DEPARTMENT OF PUBLIC WORKS

MEMORANDUM

TO: All Staff
FROM: Public Works Plan Review Team
DATE: April 25, 2024
SUBJECT: SE-24-00013 Horish

GRADING PLAN AND STORMWATER MANAGEMENT

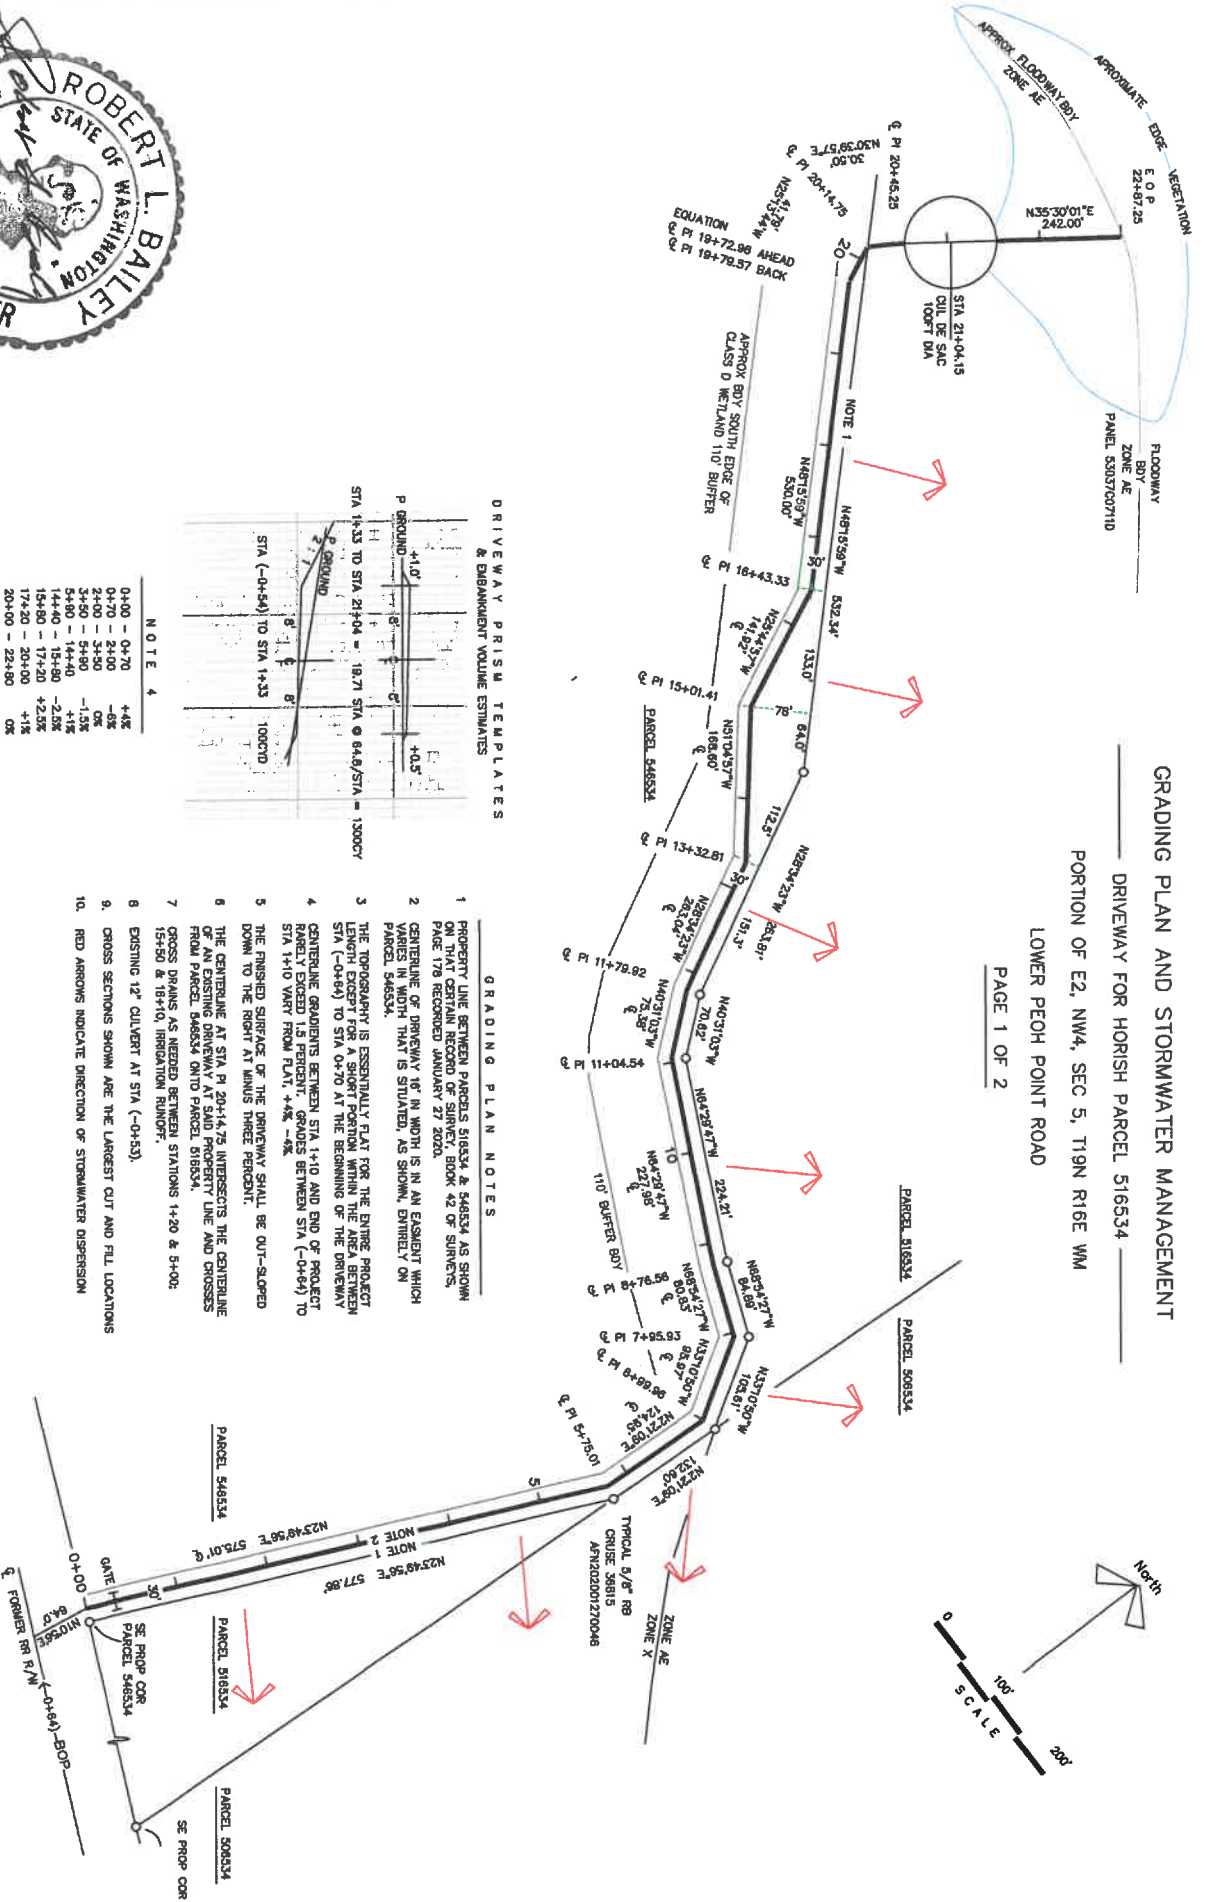
FLOOD	A portion of parcel #546534 is located in the FEMA identified special flood hazard area (100- year floodplain). Based on the site plan, the proposed driveway will be within the 100-year floodplain boundary. All activities within the floodplain require a floodplain development permit and must follow the regulations within KCC 14.08. (SC)
WATER MITIGATION/ METERING	No comments (SC)
AIRPORT	No comments. (JS)
